From: Sue Howell <Sue.Howell@arun.gov.uk>
Sent: 16 June 2022 15:51
To: Planning.Responses <Planning.Responses@arun.gov.uk>
Cc: Simon Davis <Simon.Davis@arun.gov.uk>
Subject: Planning Consultation on: AL/49/22/PL

Application ref: AL/49/22/PL

Description: Demolition of all existing buildings and structures and redevelopment of the existing car salvage and recycling facility to provide 80 No dwellings and a co-working hub, with vehicular access from Fontwell Avenue, provision of public open space, landscaping, and other associated works. This application is a Departure from the Development Plan is in CIL Zone 3 and is CIL Liable as new dwellings.

Location: Sussex Recovery Company Fontwell Avenue Eastergate PO20 3RU

Appendix 3 – Tree Survey Plan

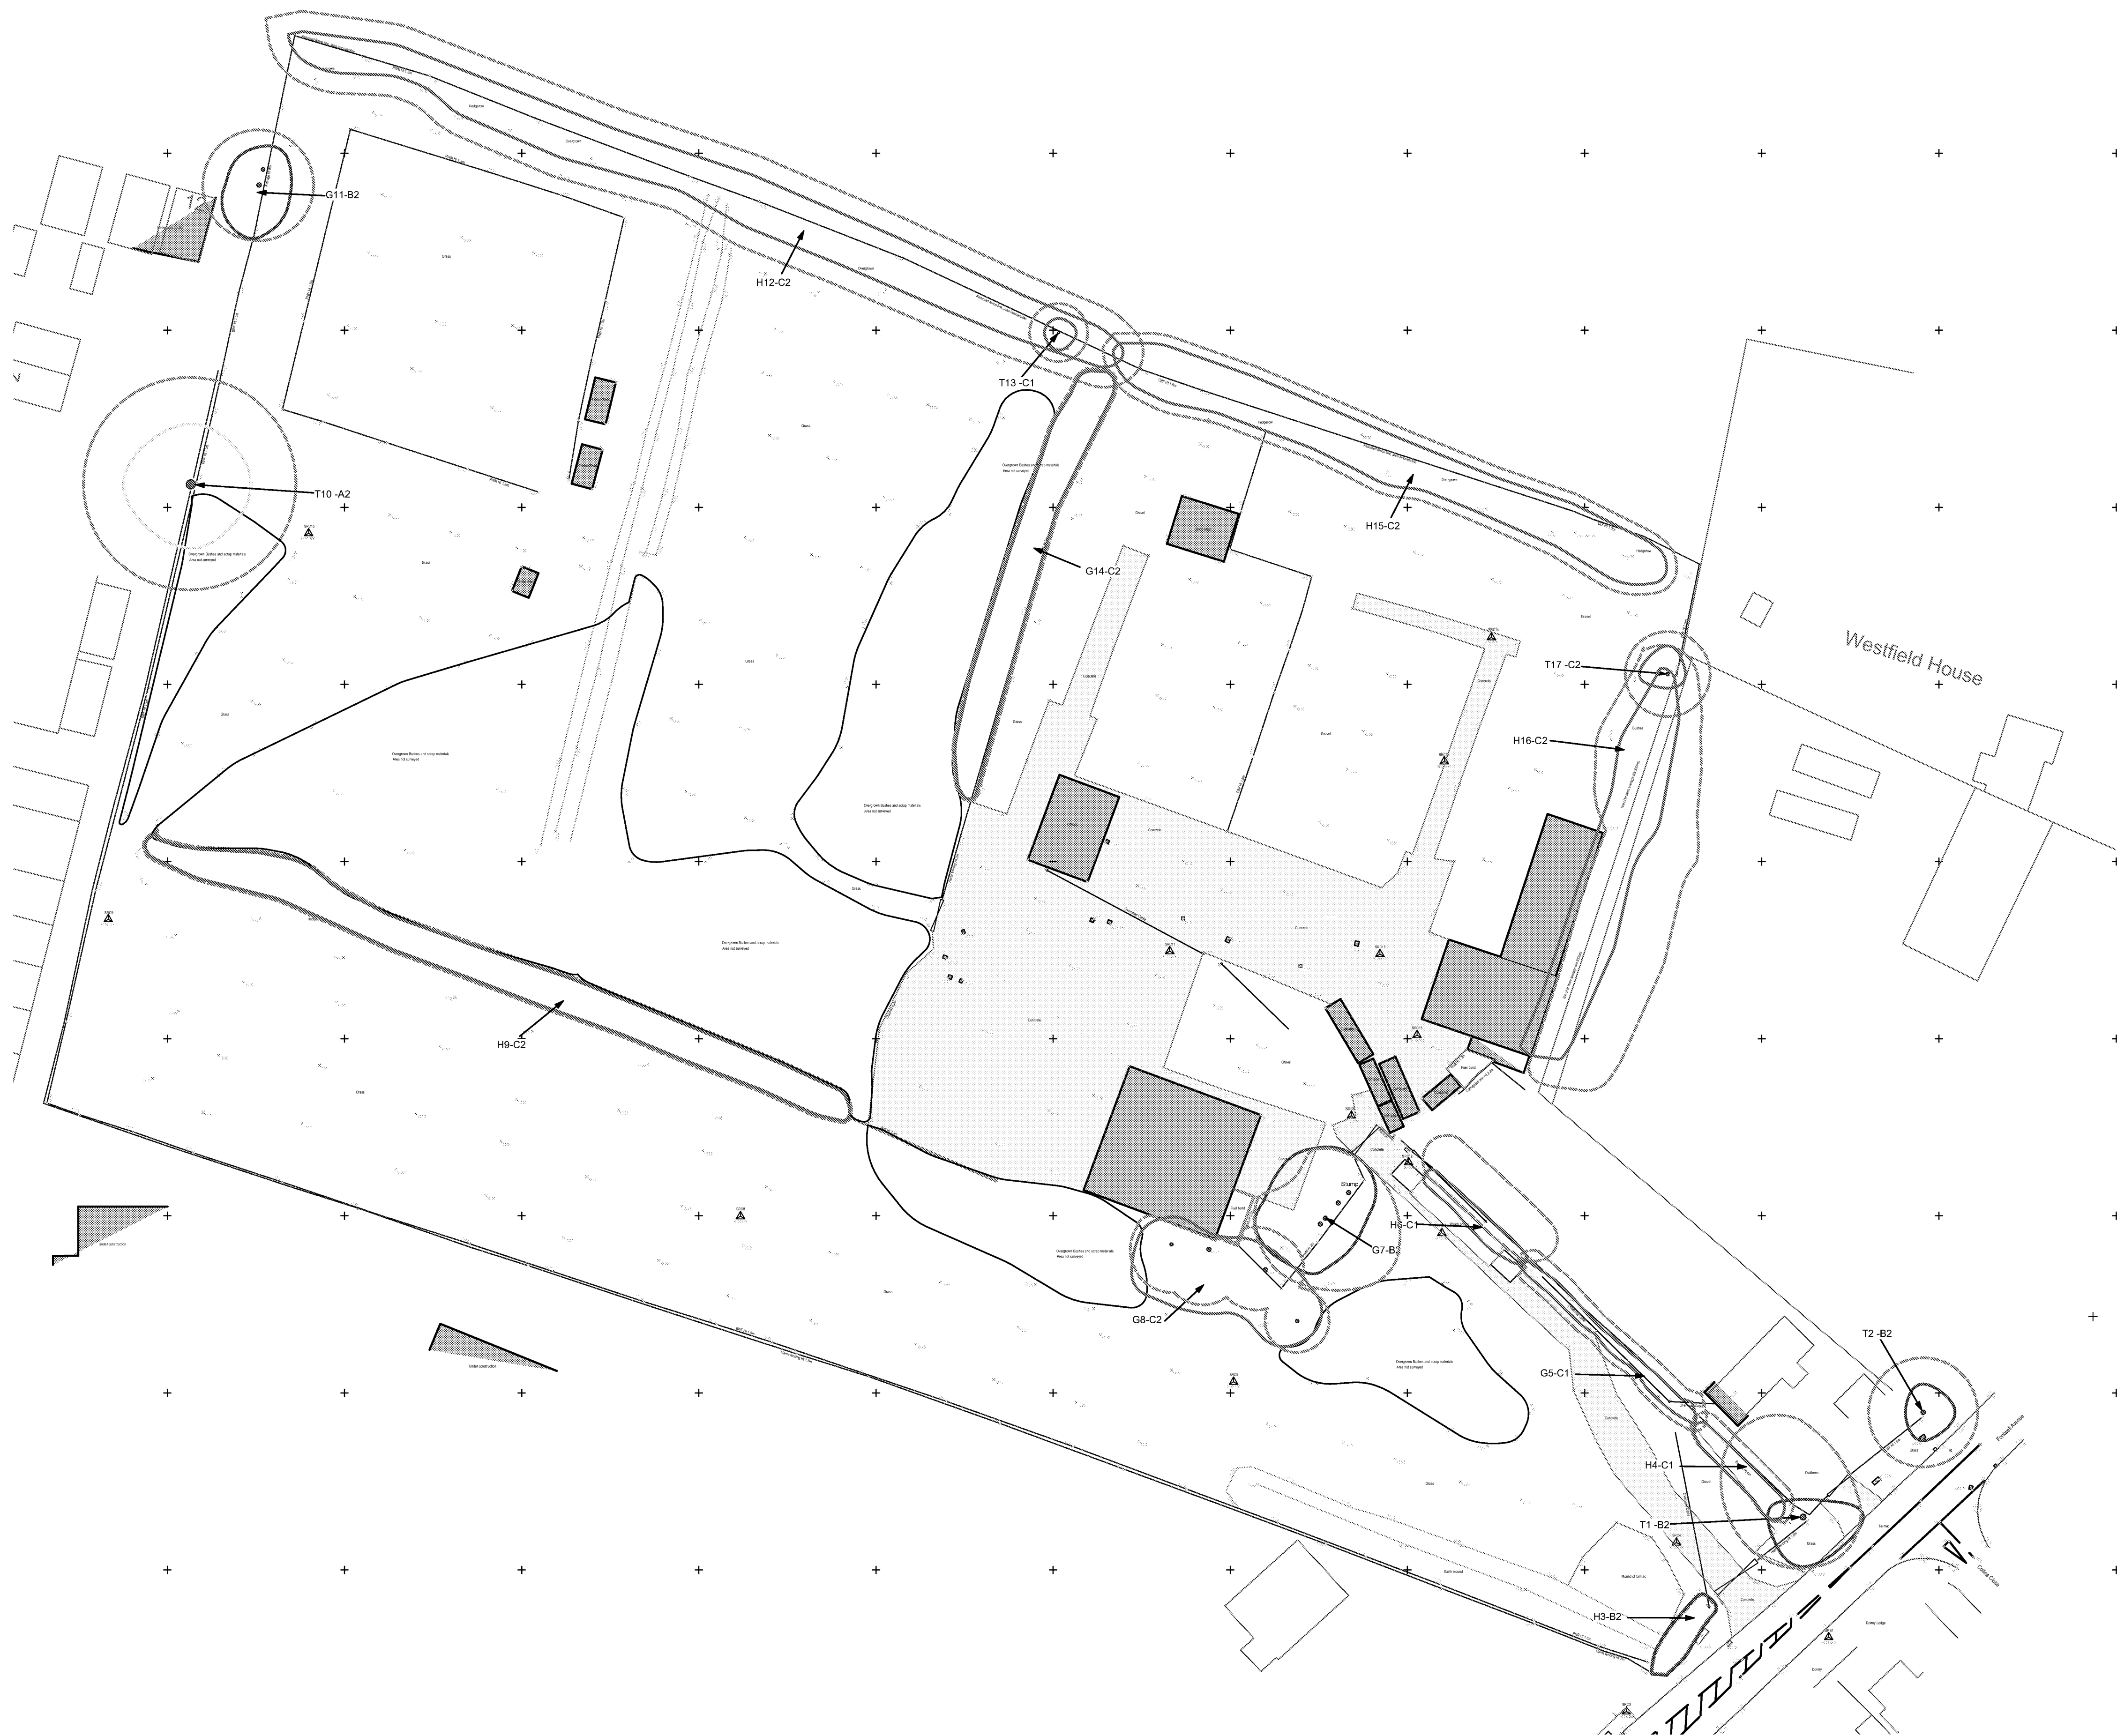
Consideration of existing trees and hedges within the site would be required and any removals agreed with Arun District Councils Tree Officer. Existing vegetation to the perimeter of these proposals may conflict with private gardens and come under pressure to be removed or pruned. Two significant Oak trees are identifiable within the site which will require protection, particularly Pedunculate Oak T1 & T10.
